Your ref: 3/2018/0024

Date: 1st February 2018

Planning Application 3/2018/0024: Conversion and extension of redundant piggery and store to one single-storey dwelling including access and parking; Outbuildings adjacent to Hammond Drive, Read BB12 7RU

EXISTING PLAN & ELEVATIONS

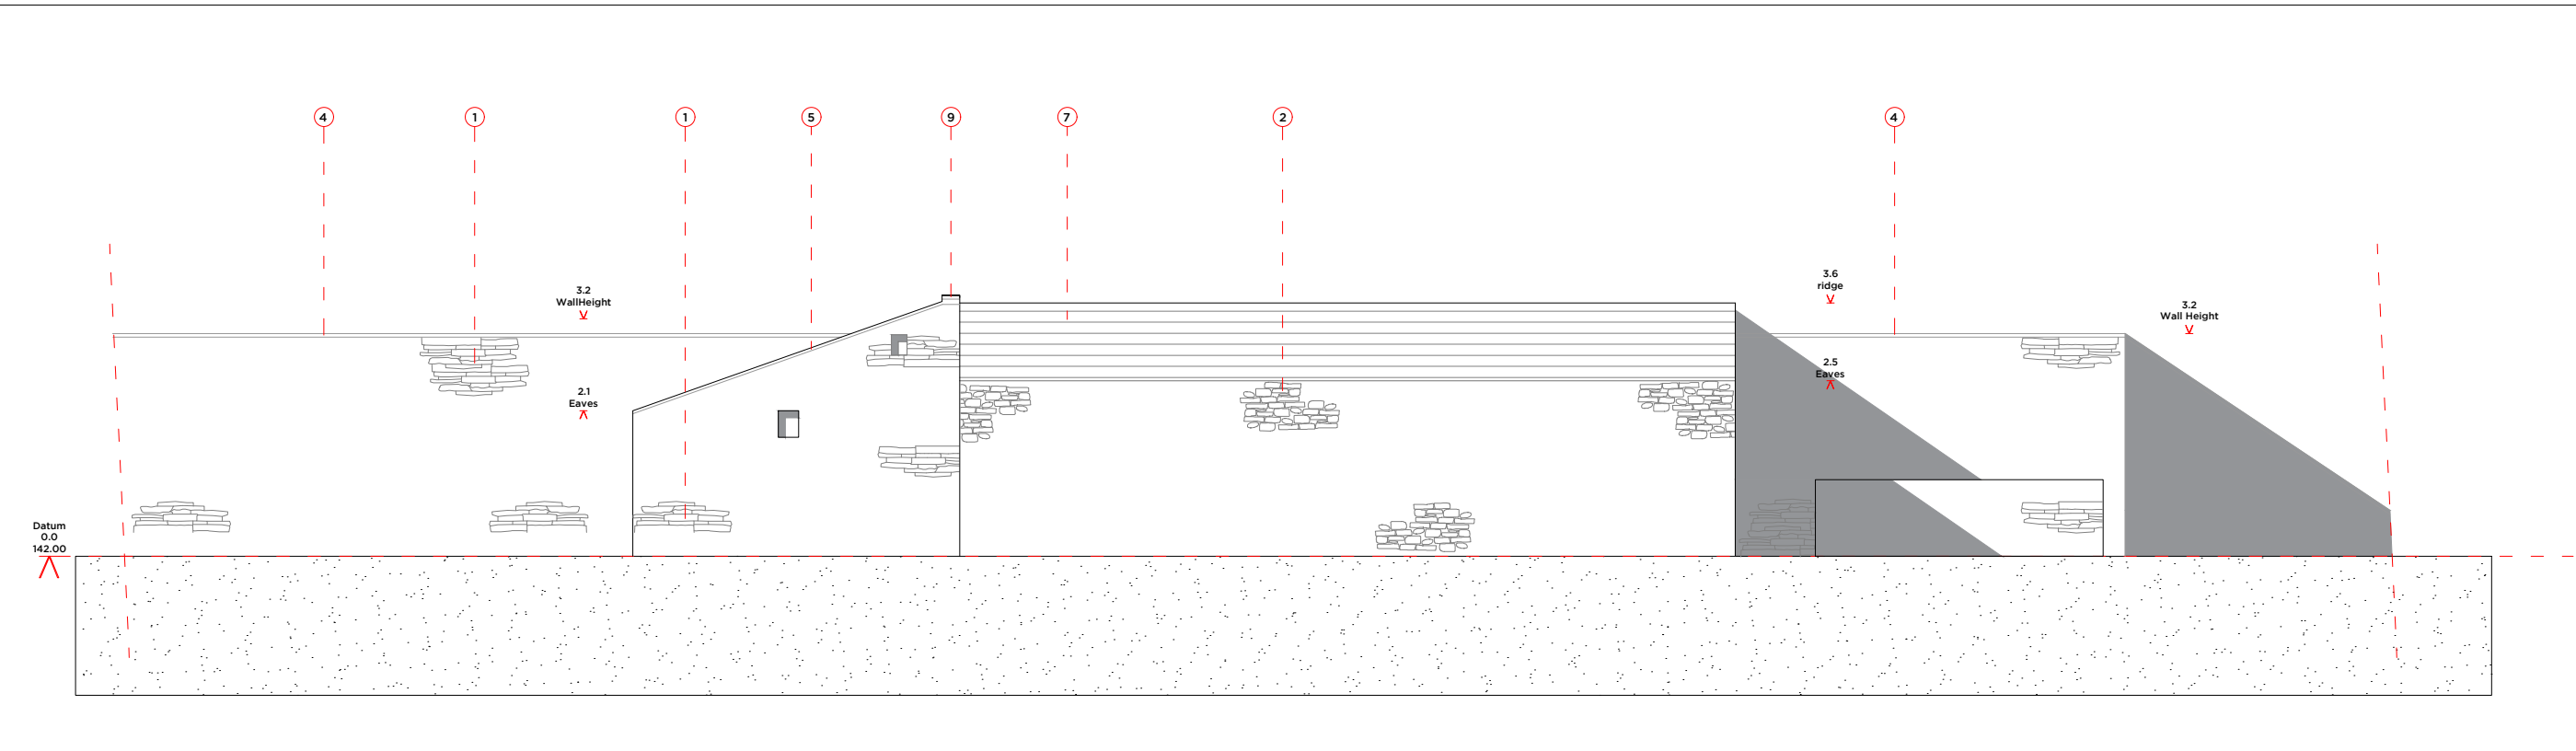
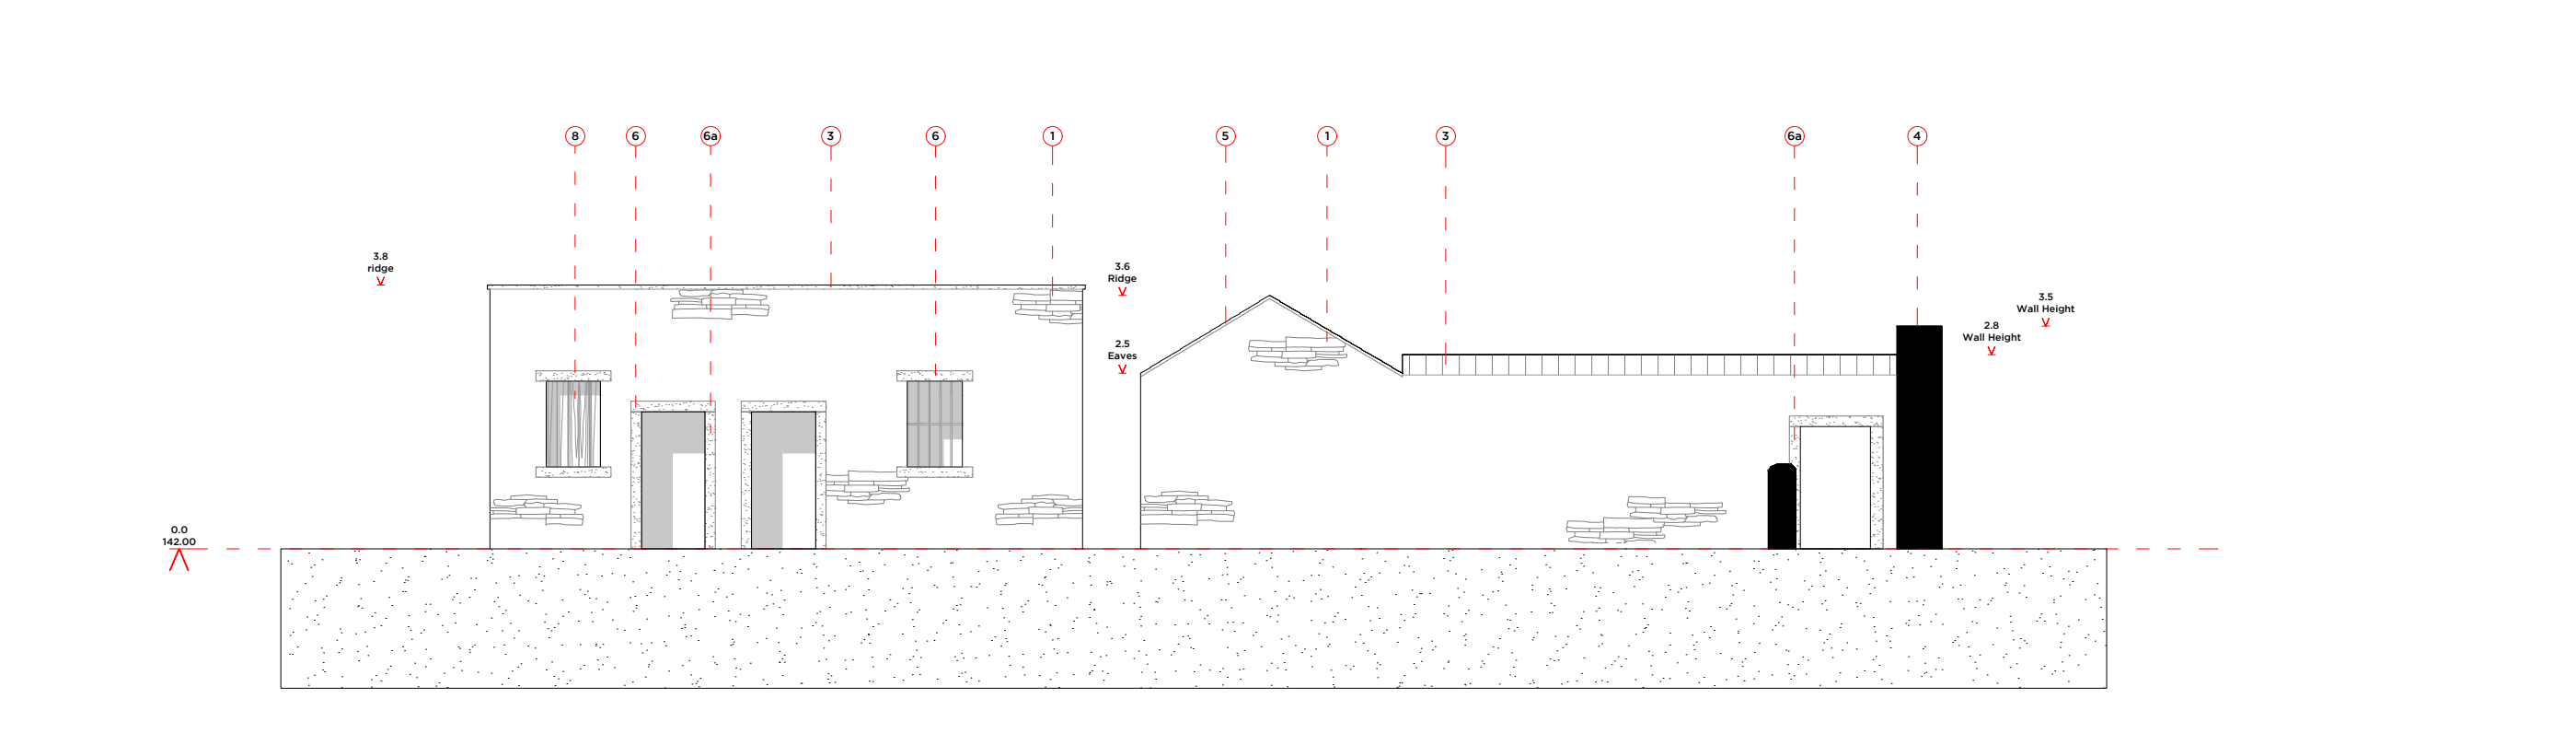
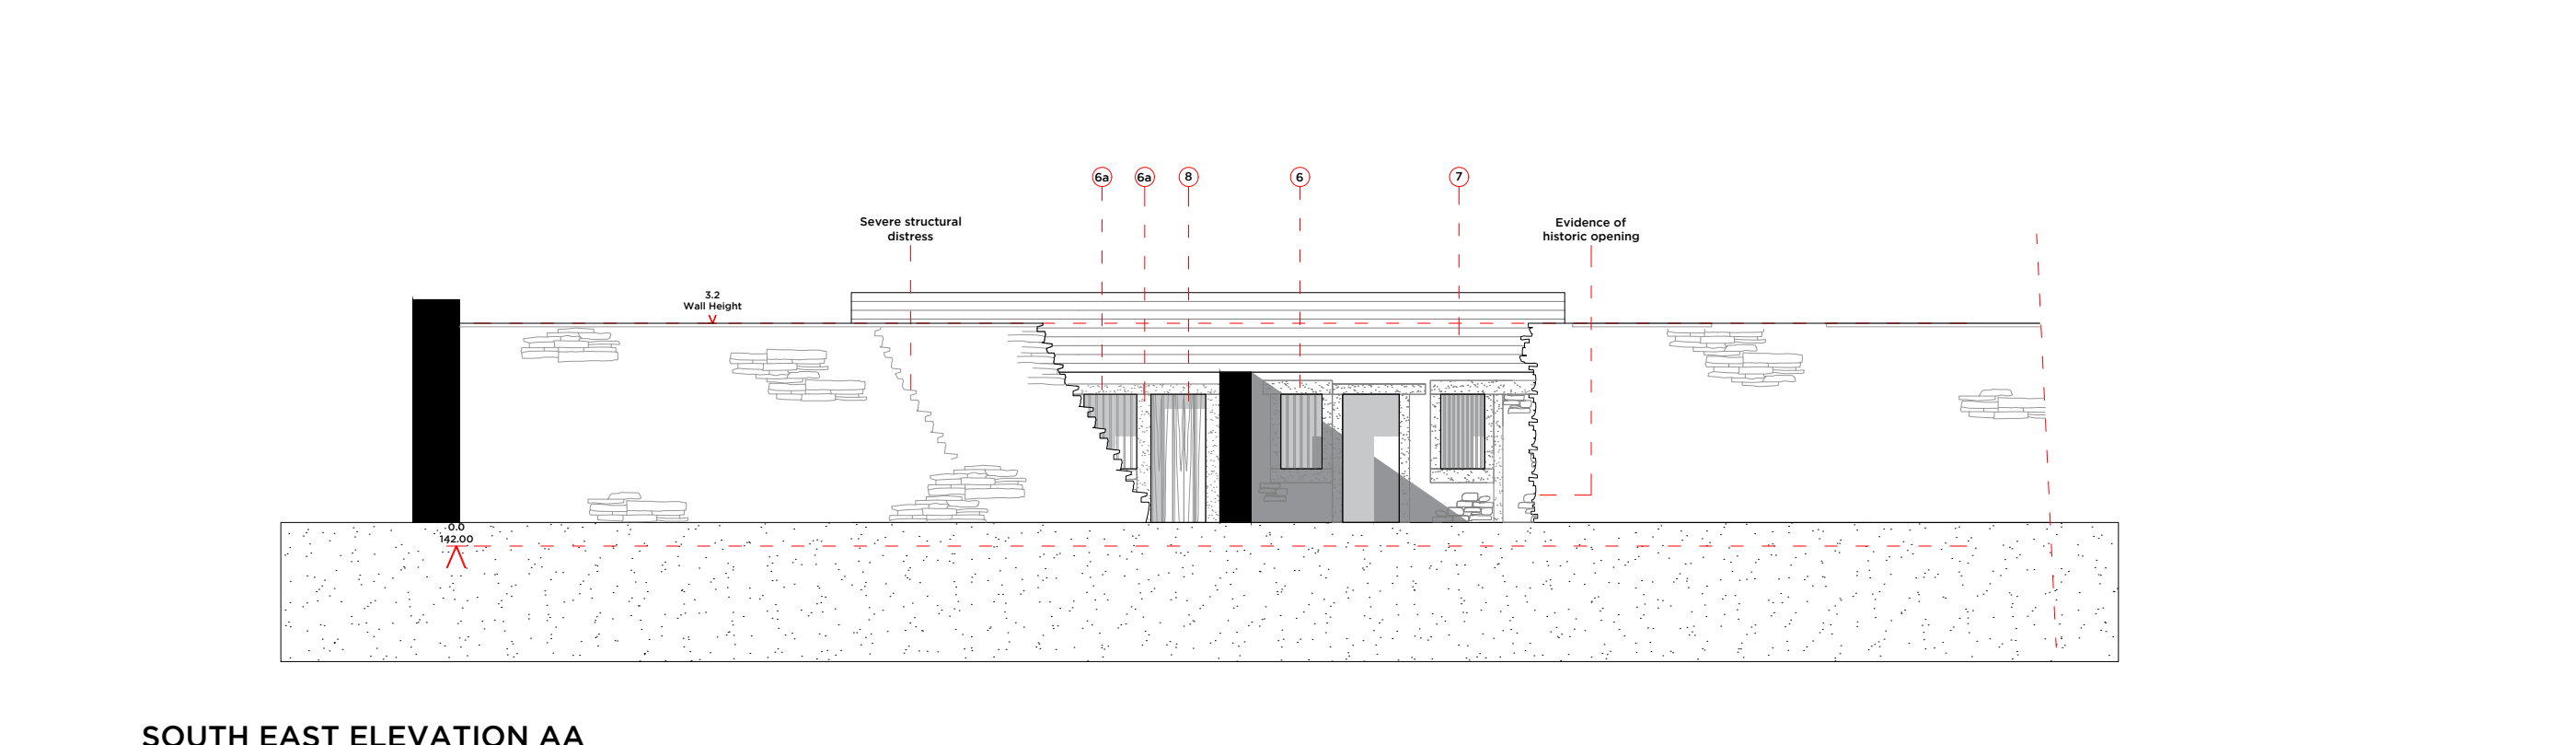
The application is accompanied by plans of the buildings as existing, a Heritage Impact Assessment (HIA, Richard K Morriss and Associates, December 2017) and a Planning Proposal document (Inspire Planning Solutions, nd). Whilst there are a few anomalies and typographical issues within the HIA it does not appear fatally flawed. As it notes the structures proposed for conversion are worthy of consideration as non-designated heritage assets (section 6) and a brief history of the area (unreferenced) and description of the site is provided. The HIA concludes that "*The scheme will result in some internal changes and some minor loss of fabric, but that is not considered to cause harm to the significance ...*" (HIA section 9). We would note that the proposed conversion will actually require the rebuilding and repair of some elements of walling and openings, underpinning works, the erection of new walls and roofs to increase the habitable floor area, the dry-lining of all habitable spaces, the insertion of a number of roof lights, the lifting of existing floors and the insertion of insulation and damp-proofing, as well as the installation of all modern services. New stud partitions are required in the northern building, but it is not clear if the existing divisions in the southern building (HIA section 5.1.1.03) are to be retained or replaced – the supplied plans 'as existing' do not show

them and the drawings in the Planning Proposal (pp.30-31) suggest that new stud walls are proposed there.

Overall the impact level of the proposed works on the extant structures could be considered to be moderate to high, rather than minor as implied in the HIA. The significance of this impact, however, is offset by the late date and relatively low importance of the structures, as well as the extant screening of the site. It would probably be assessed as 'minor negative' if Environmental Assessment methodologies were used. Given this, we would not object to the proposals as set out and if on balance the Council decides to grant permission to the application, would only recommend that some minor recording work be undertaken as a condition of any consent. This recording work should comprise the creation of a formal photographic record of the structure, the checking and correcting of the architect's plans and elevations 'as existing' (above), and the checking and correction of the HIA, followed by their submission to the Lancashire Historic Environment Record. It is probable that collecting together the photographs already provided with the application and supplementing them with a small number of detailed photographs showing the (internal and external) faces of the walls not already illustrated, plus an appropriate plan showing the photograph's location and orientation, will be all that is needed in respect of the photographic record.

- (i) The creation of a photographic record of the structures as set out in 'Understanding Historic Buildings' (Historic England 2016). It should be undertaken prior to any development work commencing.
- (ii) The checking and any necessary revision of the architect's plans 'as existing' (Peter Hitchens Architects PHA/088-300, January 2018).
- (iii) The checking and any necessary revision of the Heritage Impact Assessment provided by Richard K Morriss and Associates (December 2017)
